Re: White Barn – Chick-fil-A – *Technical Review 2*  
PA23019

**City of Marysville Community Development – Planning Division**

# PRELIMINARY SITE PLAN FOR CHICK-FIL-A MARYSVILLE

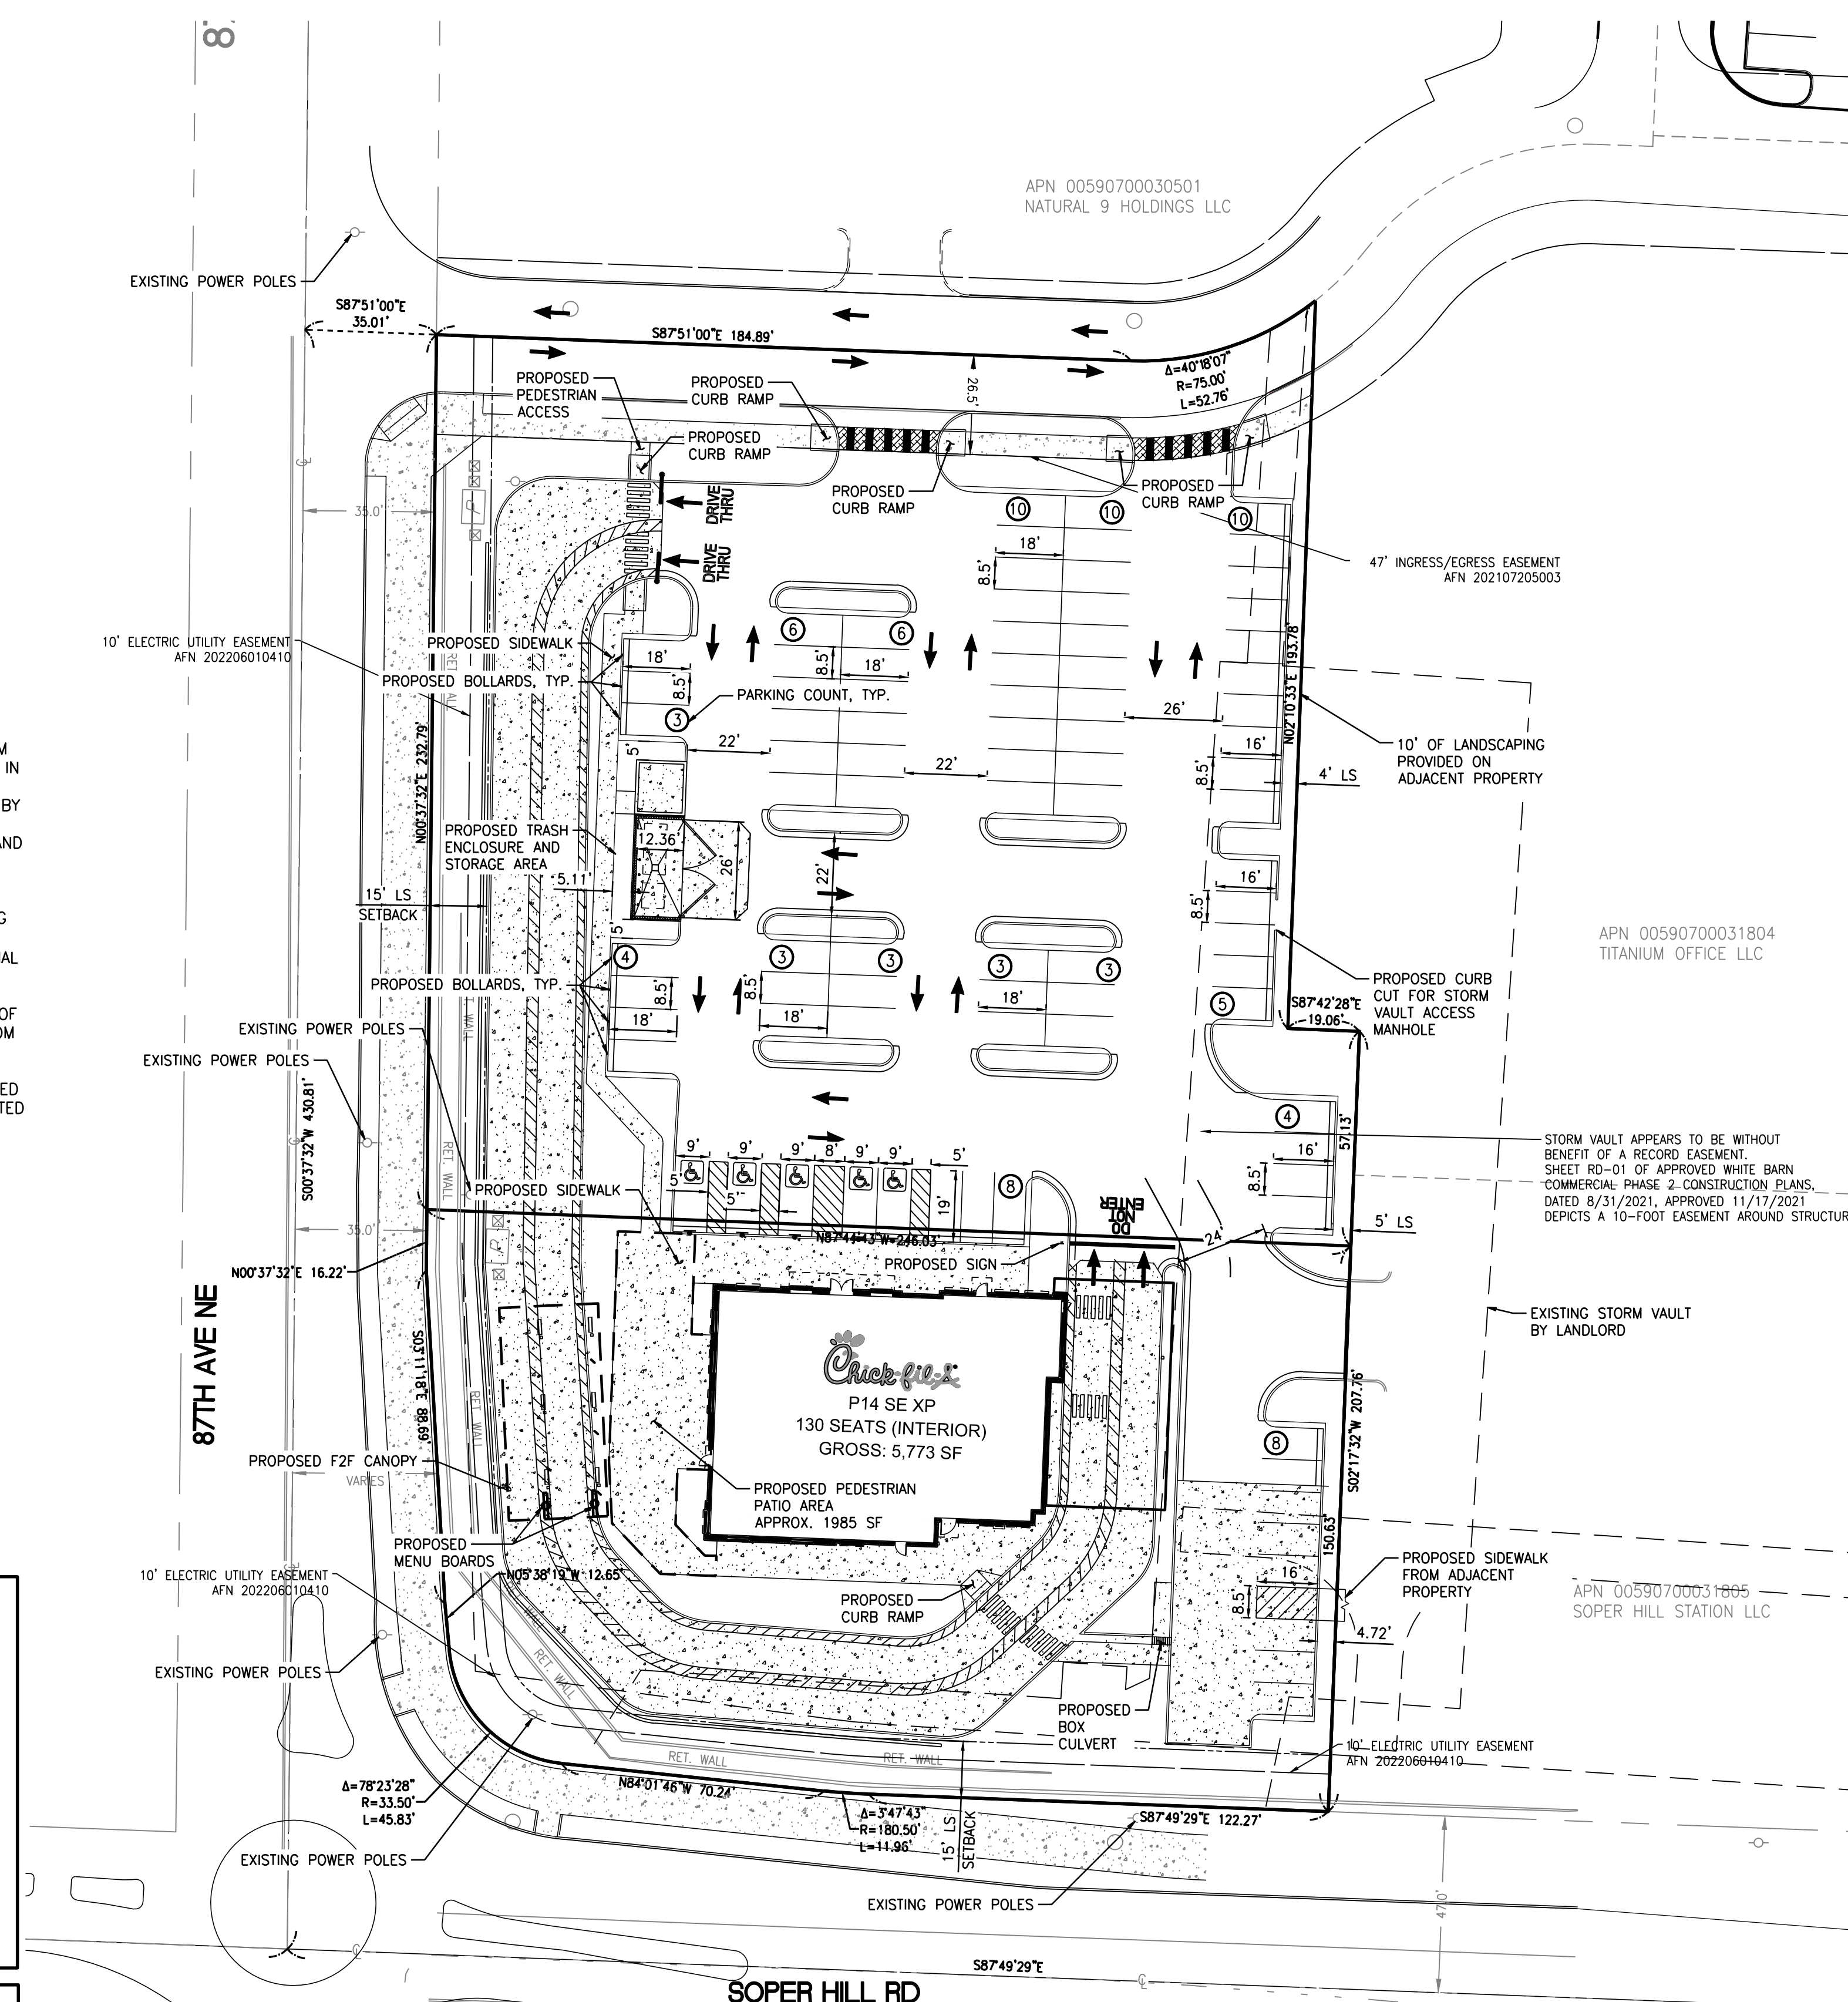
In the TR1 response memo it states that a 15' L2 landscape buffer has been provided along Soper Hill Road and 87<sup>th</sup> Avenue NE, however, in review of the revised site and landscape plans it appears only a 3 to 8' landscape buffer and a wall is proposed. In addition the buffer does not comply with the L2 screening standards. The following is the L2 planting standards guidelines:

In discussion with the Director, the City is willing to reduce the landscape buffer along Soper Hill Road and 87<sup>th</sup> Avenue NE to a 10' L2 buffer, with a decorative screen wall that is constructed with materials that are complimentary of the proposed restaurant. Colored architectural drawings and a revised screen wall will need to be submitted for Director approval. At this time it is unclear if the two examples provided would meet this criteria. The Renton, WA example would not be acceptable.

In order to accomplish the landscape buffer requirements, the restaurant may need to be relocated to the northeast.

2. The proposed pedestrian connection between Chick-fil-a and Soper Hill Station that traverses the drive-thru and parking area will be required to be constructed with decorative concrete. This detail will be required to be provided on the civil construction plans.

3. The pedestrian crossings along the north entrance shall be constructed with decorative concrete, similar to what has been installed on the White Barn development site. This detail will need to be provided on the civil construction plans.

4. Provide required open space calculations and identify the location of the required open space on the site plan. Non-residential uses shall provide pedestrian-oriented space, defined in subsection (2)(c) (see design standards for qualifications), at a rate of 2% of the site, plus 1% of the building floor area. Required sidewalks and walkways shall not count as pedestrian-oriented space. See [MMC 22C.070.100\(2\)\(c\)](#) for examples of qualifying pedestrian oriented open space.

5. As noted in Comment No. 1 above the proposed landscaping does not comply with the provisions outlined in [MMC Chapter 22C.070 East Sunnyside – Whiskey Ridge Subarea – Design Requirements](#). The landscape plan shall be amended, as follows:

- a. Landscape buffer widths and plantings on the north (10' L3), south and west perimeters (10' L2 and decorative wall).
  - b. Provide a minimum 5' wide L1 landscape buffer around the proposed dumpster enclosure.

- c. Ensure the buffers comply with the plantings required for the type of buffer (i.e. L2, L3 & L4). Attached is the Administrative Landscaping Guidelines for reference.

- d. Provide parking lot landscaping calculations. 10% of the required parking areas shall be landscaped with L4 landscaping. This excludes required perimeter buffers.
